From: Amanda Scholes on behalf of Planning.Responses
Sent: 03 November 2017 08:25
To: Planning Scanning
Subject: FW: planning application consultation - LU/307/17/PL
Attachments: GIS.pdf; 02.11.2017 Plan- 020204.pdf

LU/307/17/PL

PLAN-020204

Proposal: Demolition of promenade shelter & construction of cafe & kite surfing school with roof terrace & associated works.
Site: Promenade Shelter, Sea Road, Littlehampton, BN16 2NA.
LU/307/17/PL

Ground floor plan | proposed

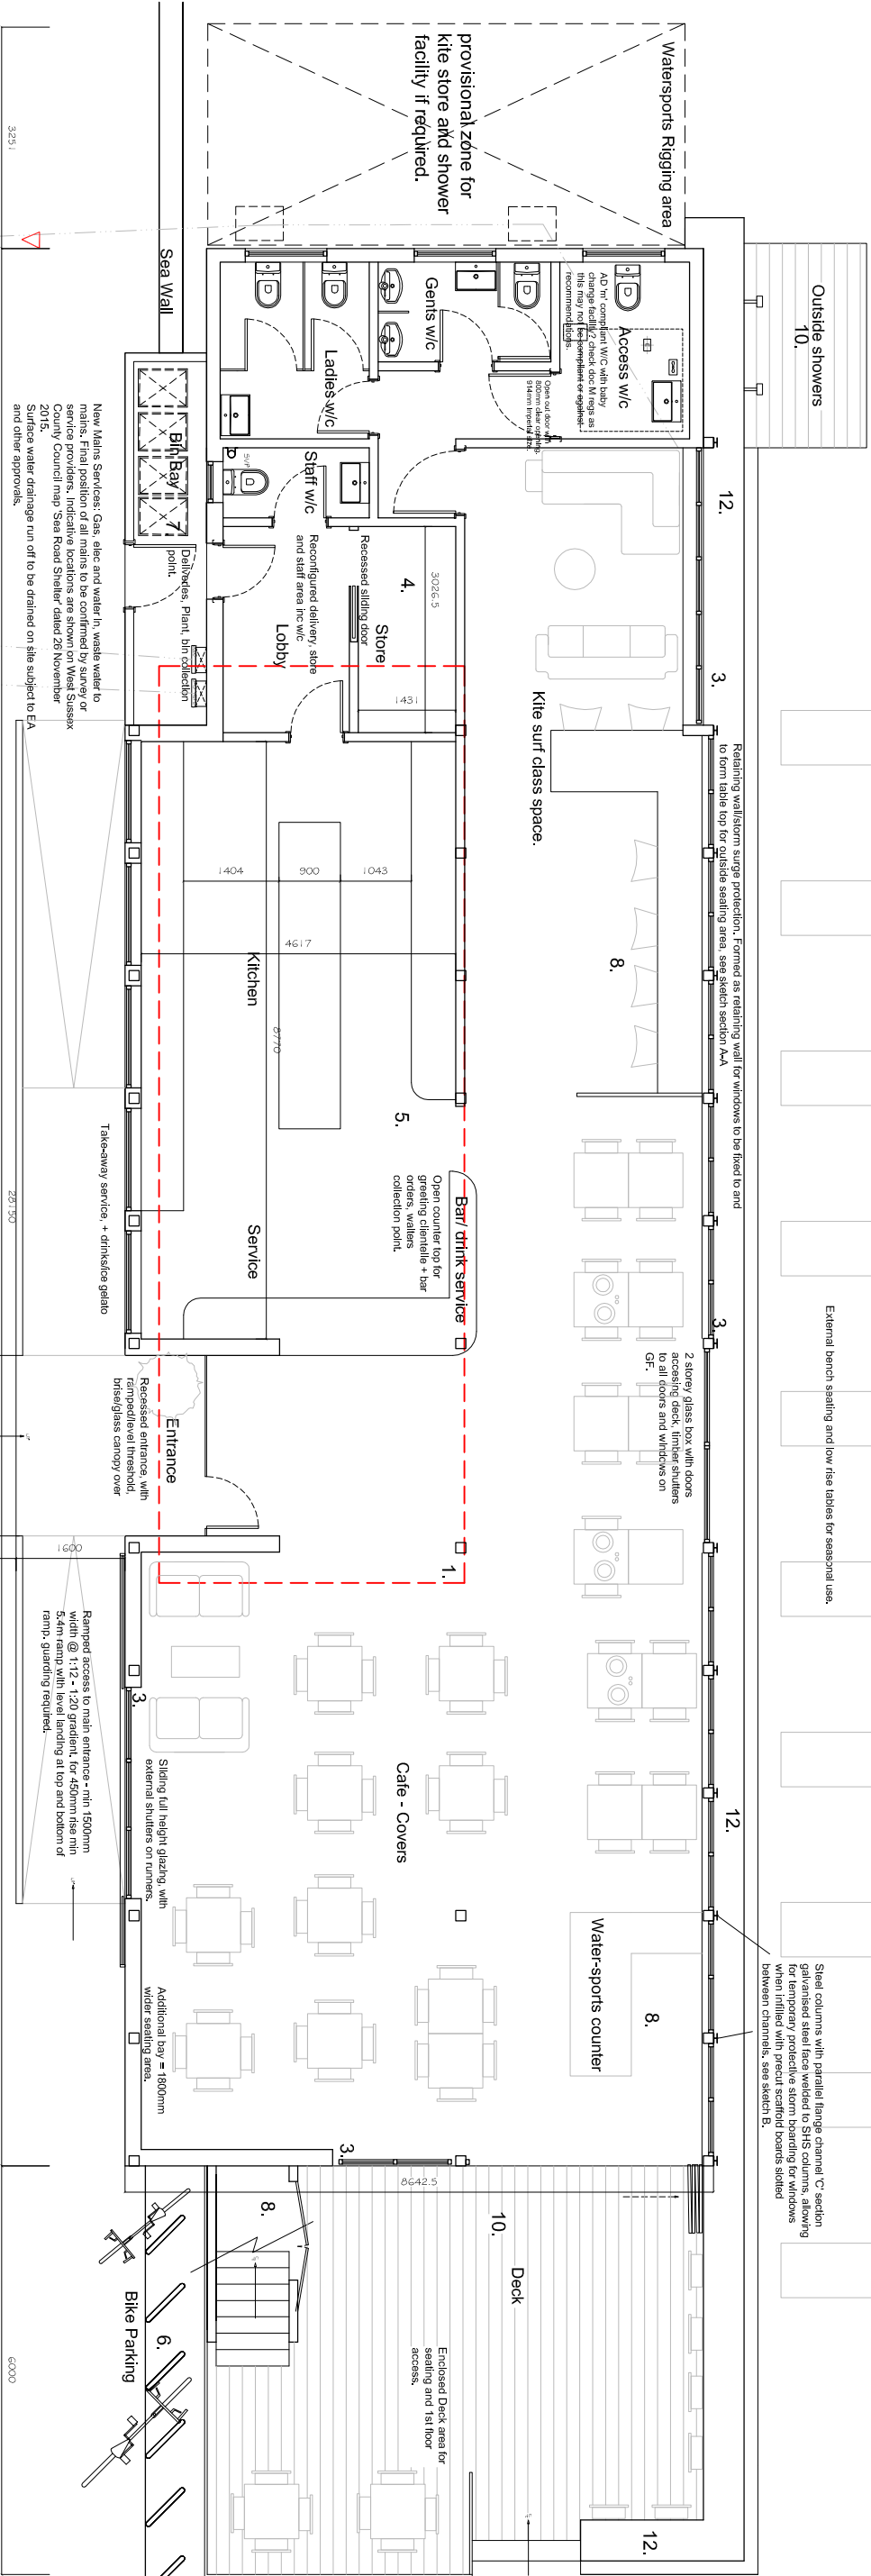
The applicant should be advised that a wastewater grease trap should be provided on the kitchen waste pipe or drain installed and maintained by the owner or operator of the premises.
